Application by Ecotricity (Heck Fen Solar) Limited
Heckington Fen Solar Park

The Examining Authority's written questions and requests for information (ExQ2) Issued on 19 December 2023

FIGURE 4.1e PROPOSED ECOLOGICAL ENHANCEMENTS FOR OPERATIONAL ENERGY PARK

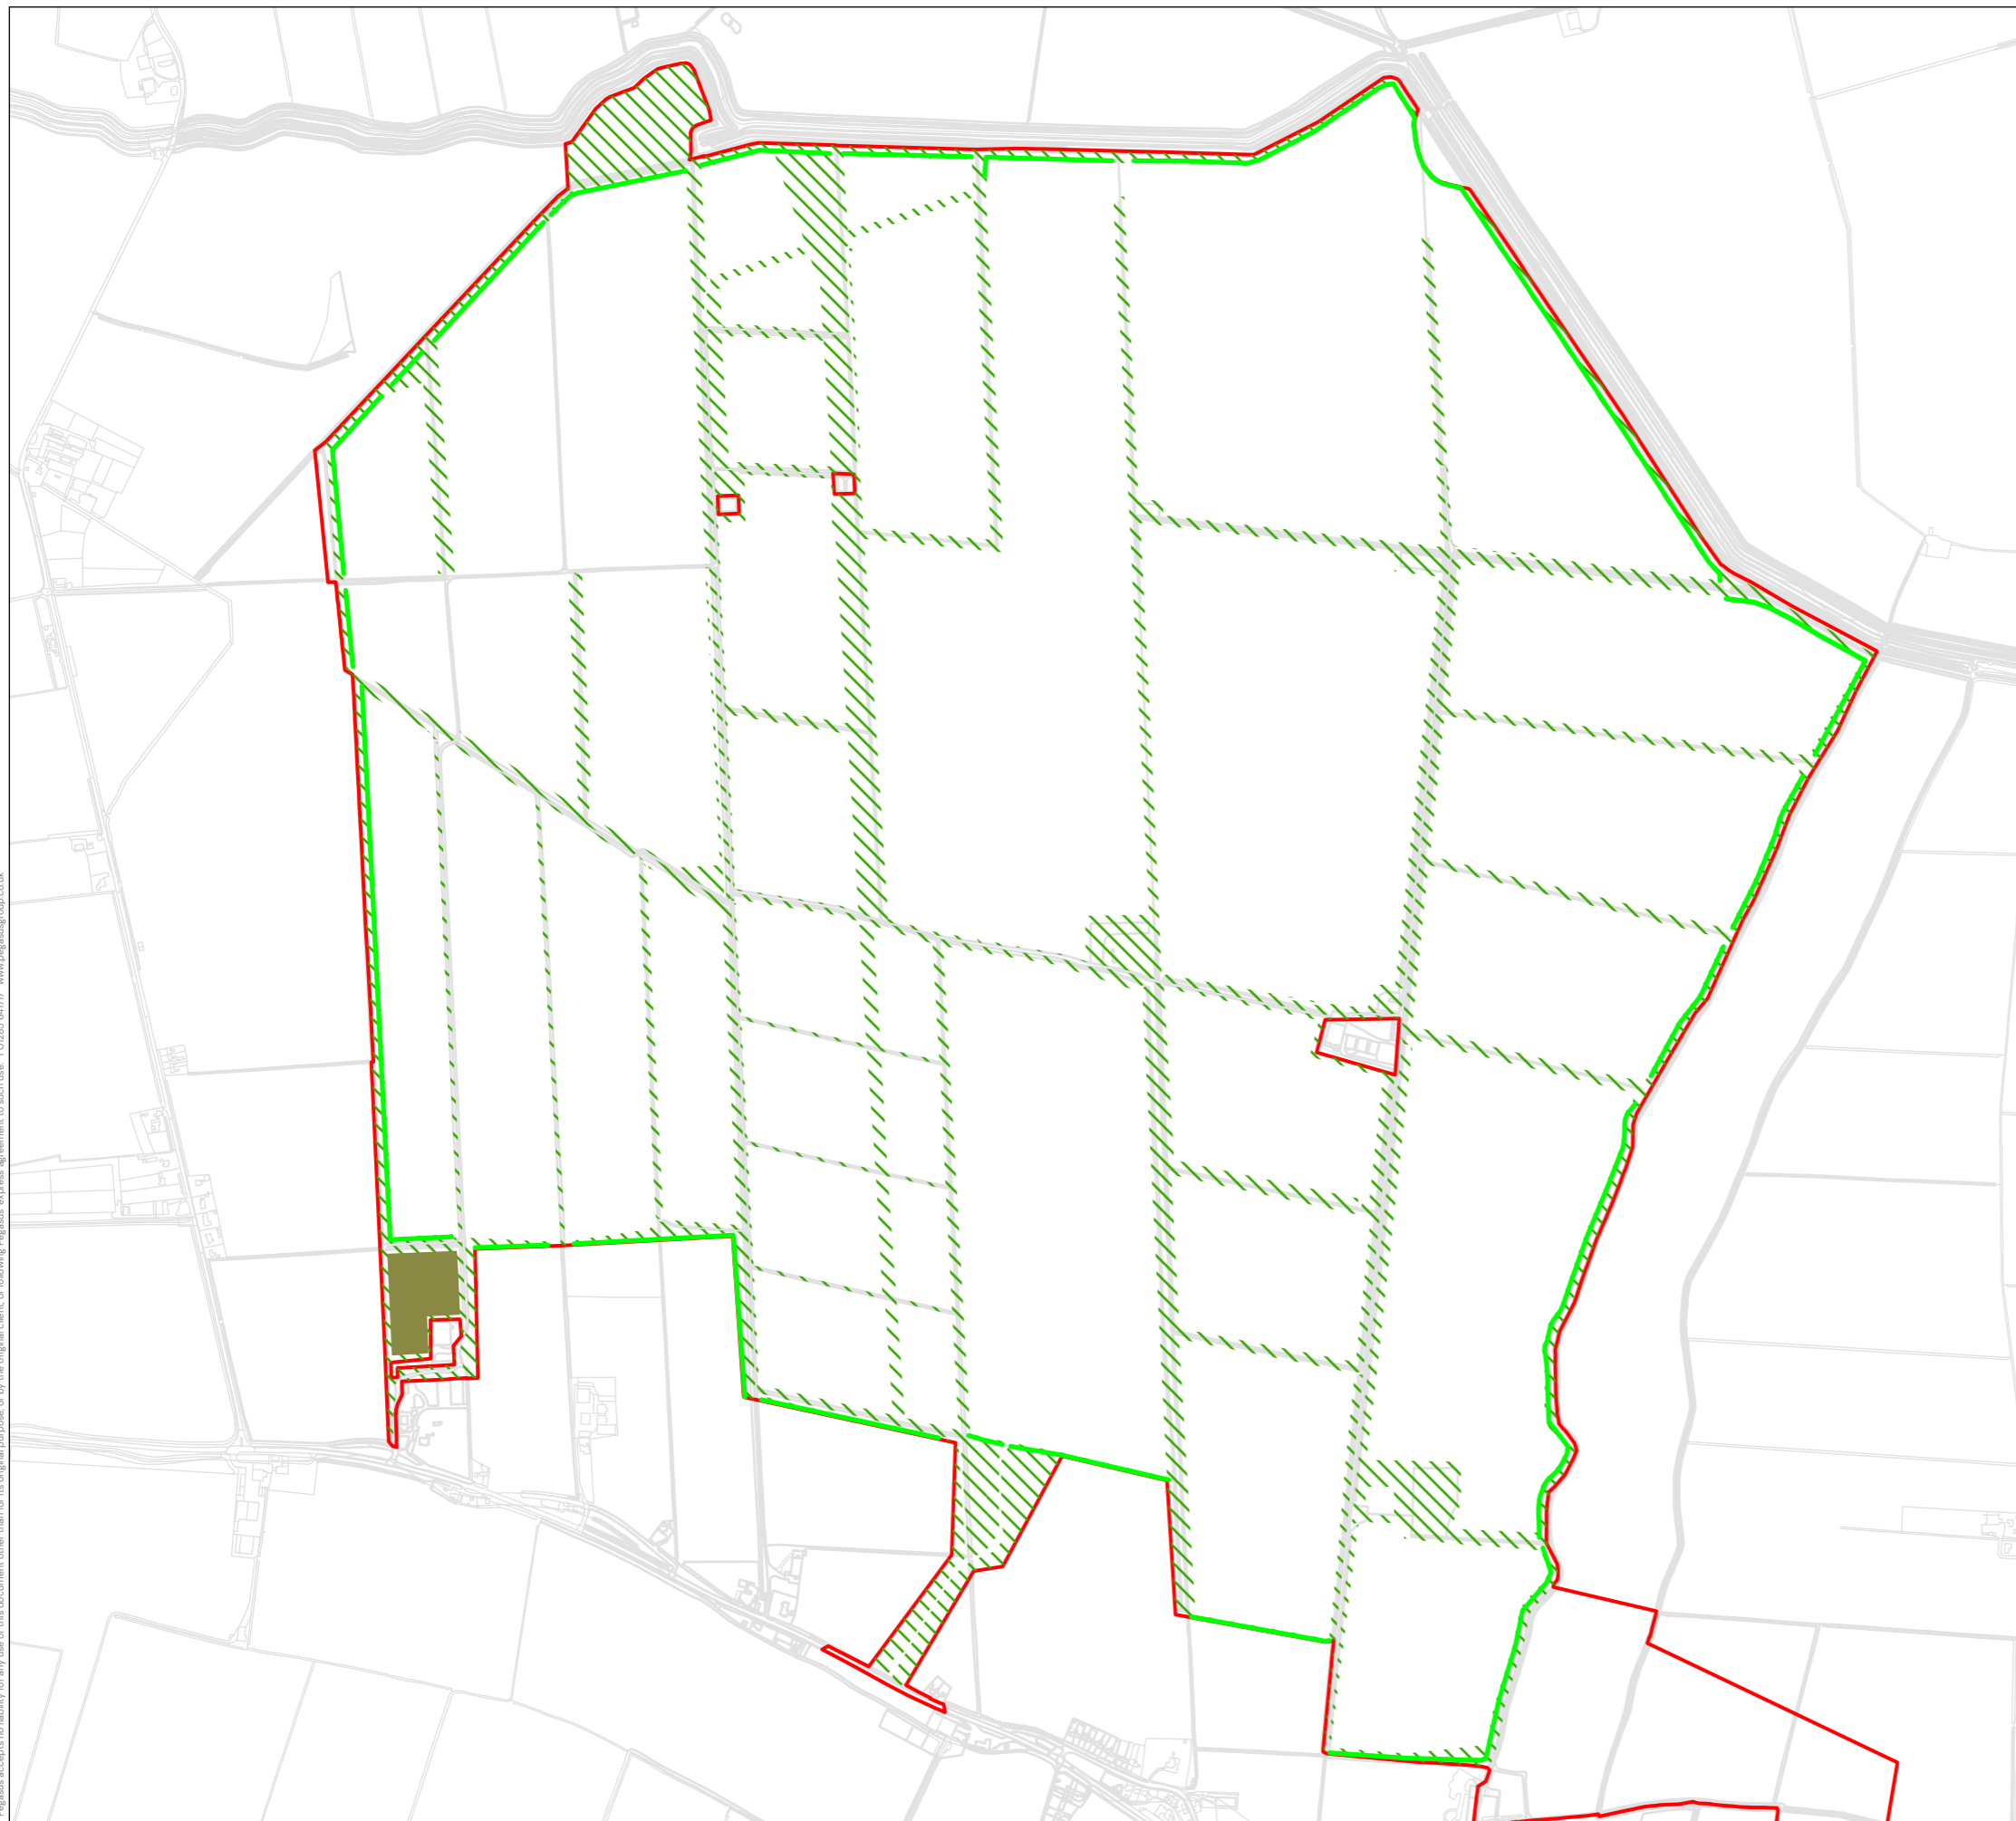
BIO 2.5	North Kesteven District Council Forestry Commission	<p>The updated outline LEMP [REP3-021] includes at paragraph 5.5.2 confirmation that a woodland management plan will be created for the final LEMP, which will cover both the community orchard and the replacement woodland planting in the north-west corner of the Energy Park site.</p>

ExQ2	Question to:	Question:
		NKDC and the Forestry Commission are asked to comment on this additional provision within the LEMP.
BIO 2.6	Applicant	<p>NKDC seek for the replacement planting period within R8 (3) to be increased from five years to seven years in accordance with their 2020 Tree Strategy [REP3-042], and that R21 should be bound by the same replanting period [ISH4 AP6, REP3-040].</p> <p>The Applicant is asked to further consider an increase to the replacement planting clause given that mitigation tree planting is anticipated to mature beyond the five year period.</p>
BIO 2.7	Applicant	<p>Section 5.2 of the outline LEMP [REP3-022] includes provisions for investigating growth failure of trees.</p> <p>Could the Applicant:</p> <ul style="list-style-type: none">i) Detail what other measures are included to address potential failures of both tree and hedge mitigation planting and how is this to be managed and secured.ii) Explain what monitoring is in place to ensure the success of mitigation planting in the light of changing climatic conditions.

APPENDIX 2 – ARBORICULTURAL IMPACT ASSESSMENT AND TREE PROTECTION PLAN

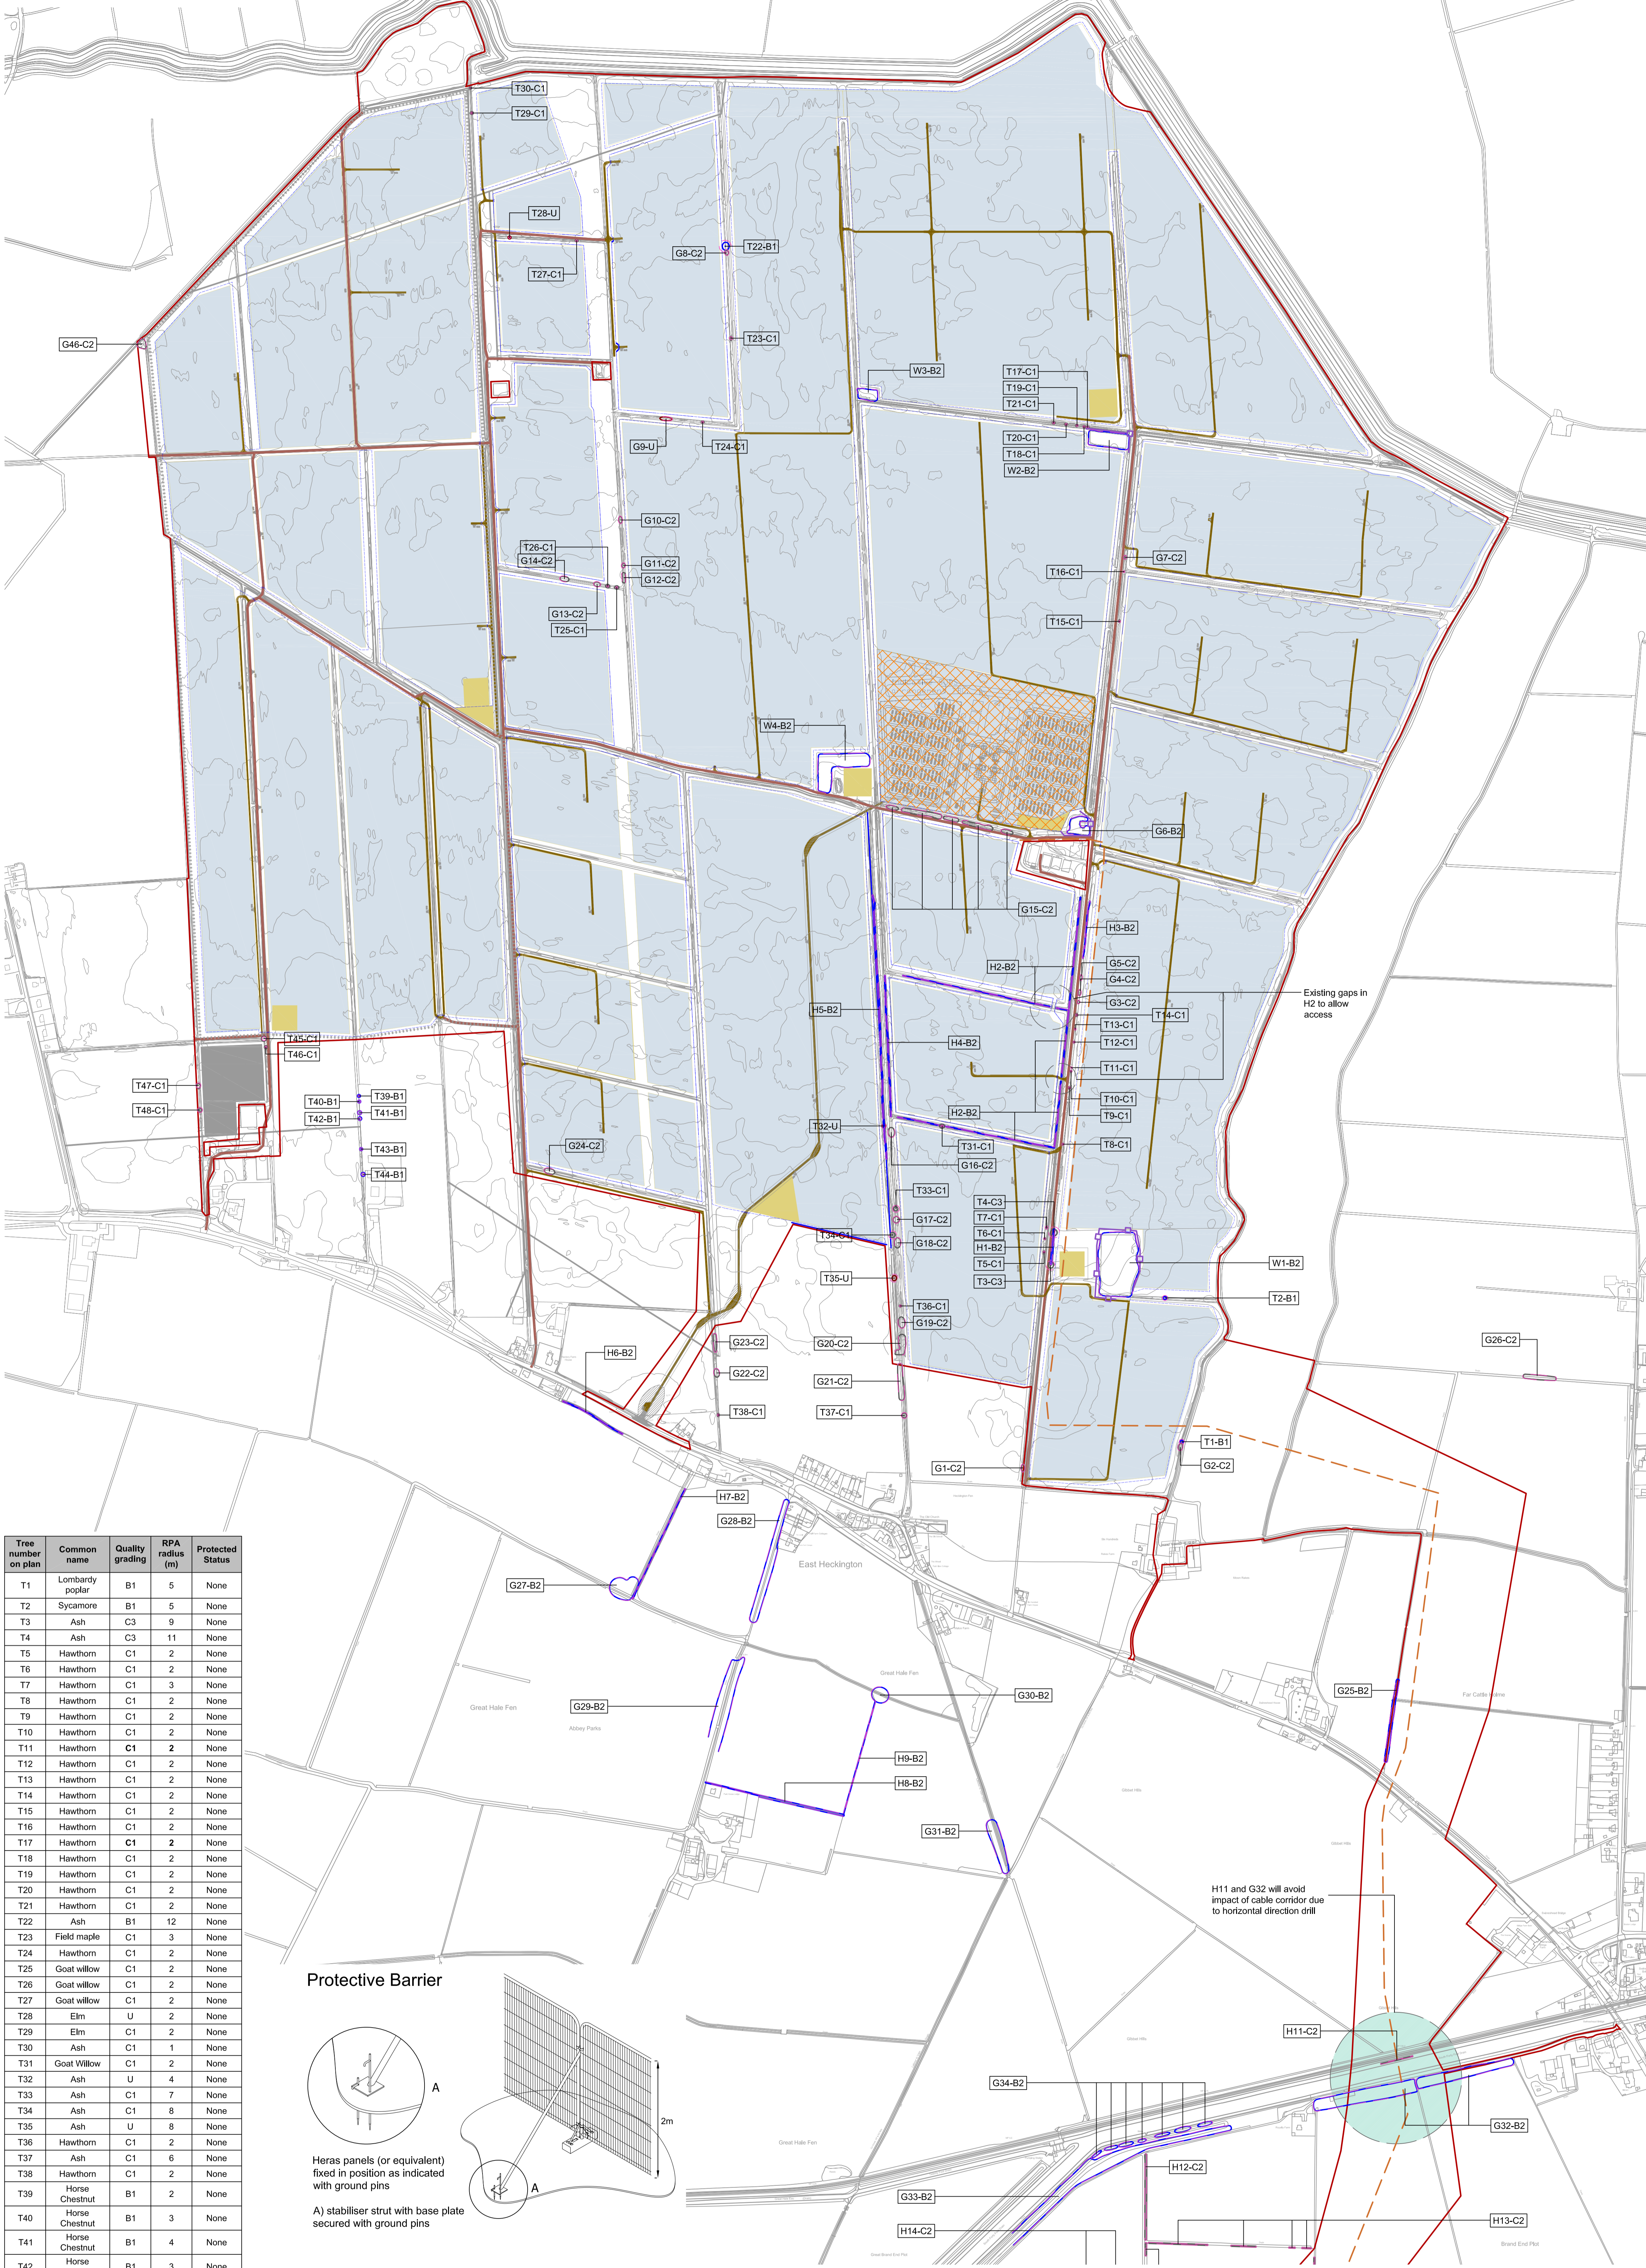
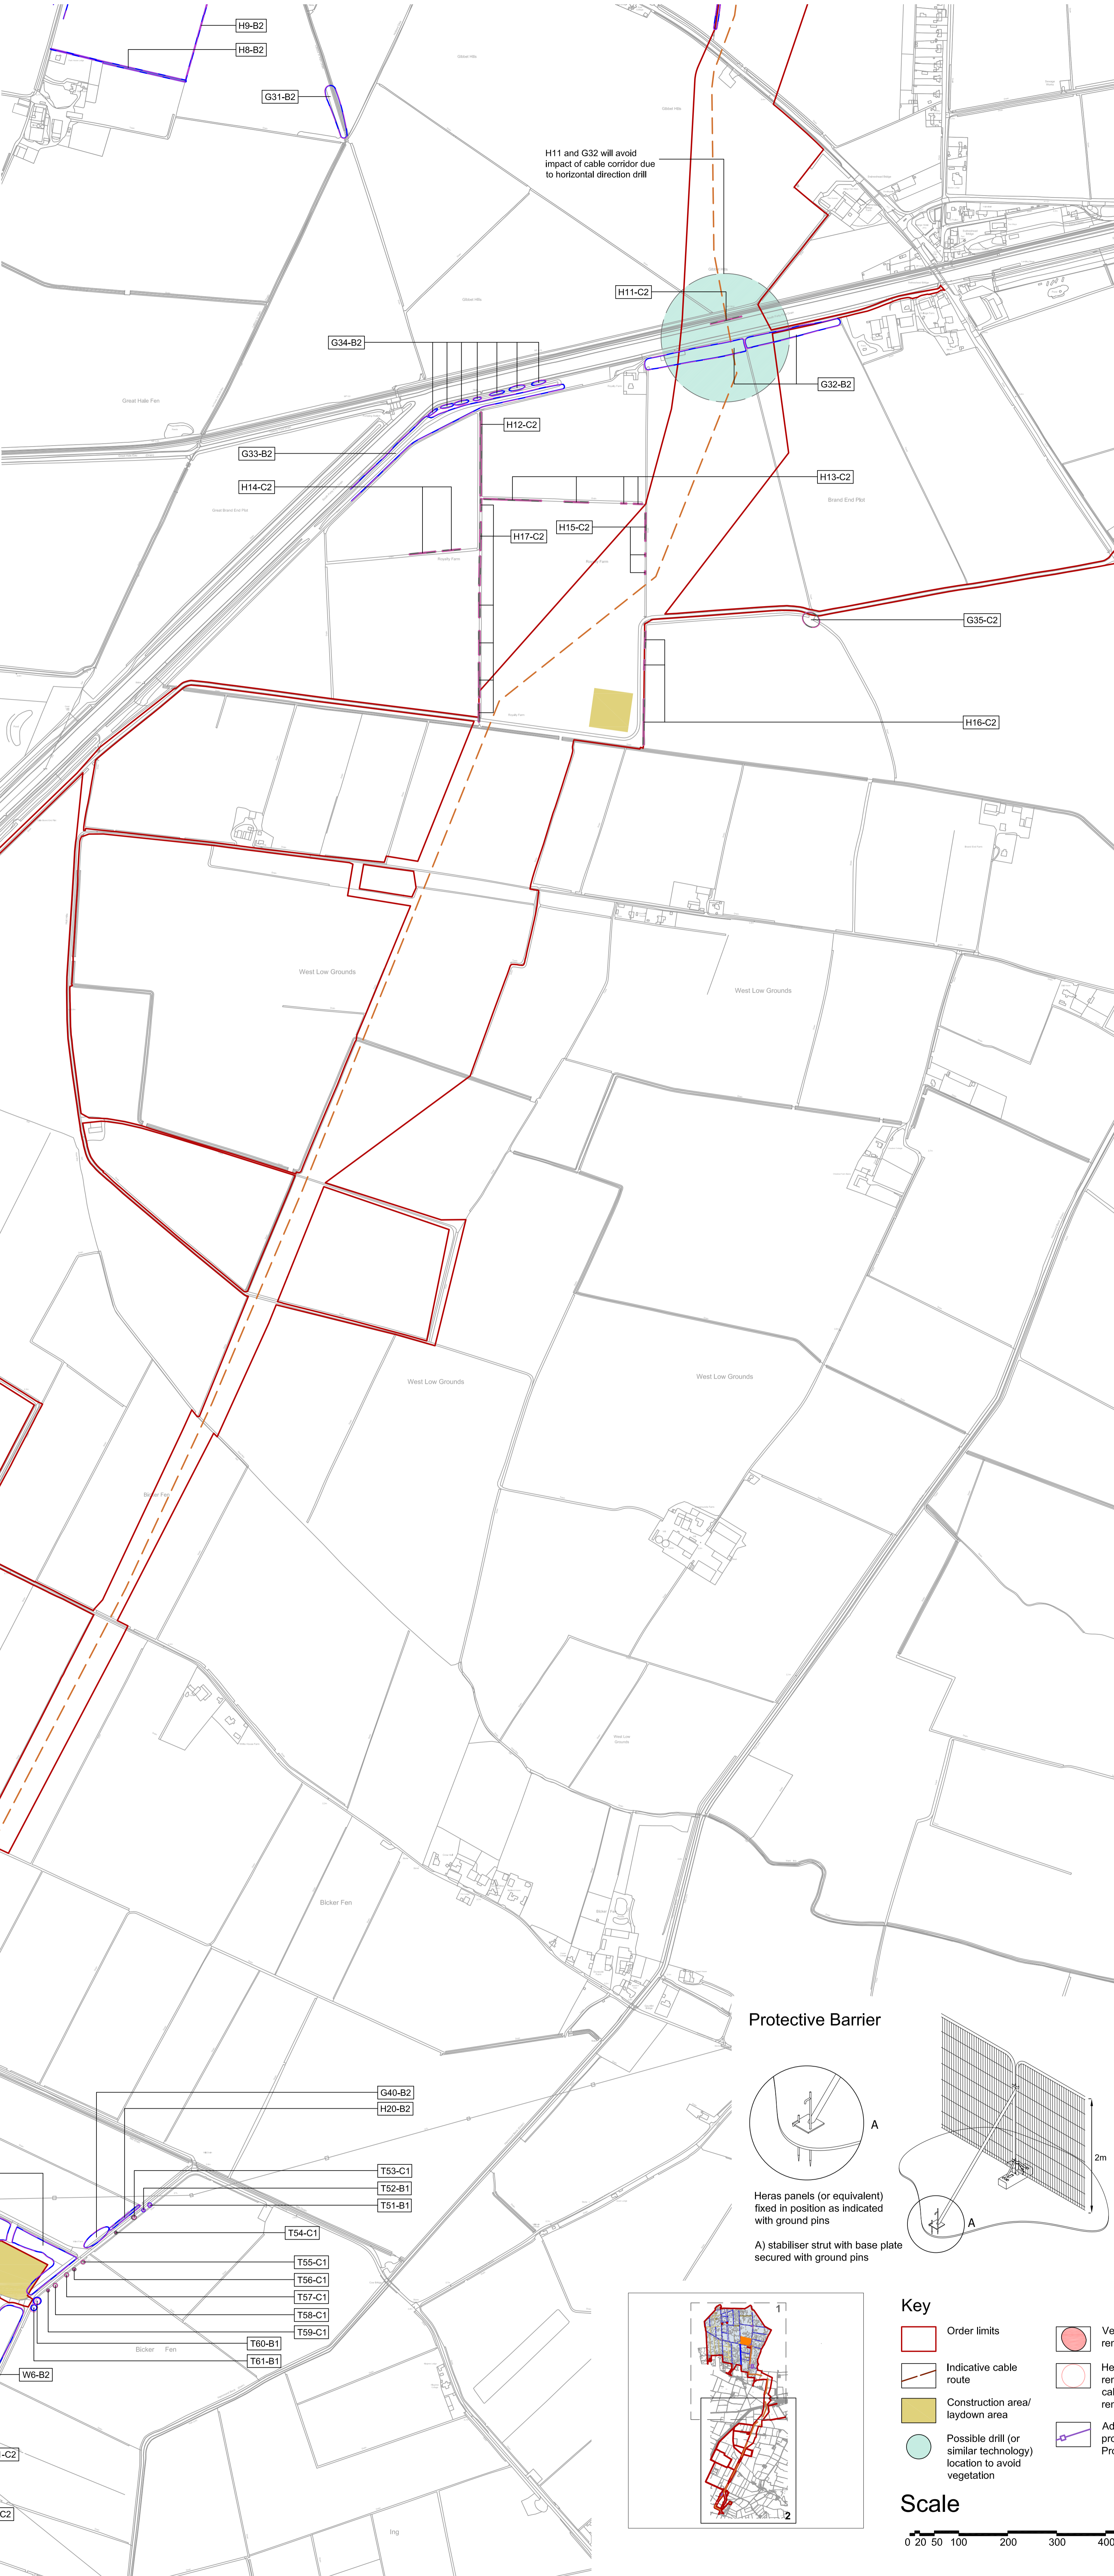
BIO 2.8	North Kesteven District Council	<p>The Applicant's response to NKDC's WR [REP2-109], followed by the Applicant's written summary of ISH4 agenda item 5 [REP3-039] confirms that landowners have not consented to a survey of the potential veteran oak tree within group G39. The outline Construction and Environmental Management Plan (CEMP) [REP3-019] has been updated at paragraph 7.37 to include provision for further survey work.</p> <p>NKDC are asked to confirm if they are satisfied with this approach and whether R13 would adequately secure the suite of pre-commencement surveys set out in paragraphs 7.33 to 7.37 of the outline CEMP.</p>
BIO 2.9	Applicant	The D3 cover letter [REP3-001] part 6 indicates a change to the minimum height of transplanted trees from a minimum of 2.5m to 1.5m.

ExQ2	Question to:	Question:
		<p>Could the Applicant:</p> <ul style="list-style-type: none"> i) Indicate where the amended height is shown in the submitted plans/documents. ii) Further explain the reasons for this change. iii) Indicate any implications for the ES.
BIO 2.10	Applicant	<p>The outline LEMP [REP3-021] includes a schedule of management of maintenance.</p> <p>Could the Applicant explain the amendment to hedgerow cutting with section 6, ref 6.1.7 (Schedule of Management of Maintenance, establishment years 0-5) which has amended the height of site boundary hedgerows from '<i>a minimum</i>' to '<i>an approximate</i>' height of 5m.</p>
BIO 2.11	Applicant	<p>BBC in their comments on the outline LEMP monitoring and review [REP3-048] suggest that monitoring results should be submitted to the Lincolnshire Environmental Records Centre held by the Greater Lincolnshire Nature Partnership and refer to their involvement with the Local Nature Recovery Strategy and monitoring county wide habitat connectivity and recovery.</p> <p>The Applicant is asked to respond to this suggestion by BBC.</p>
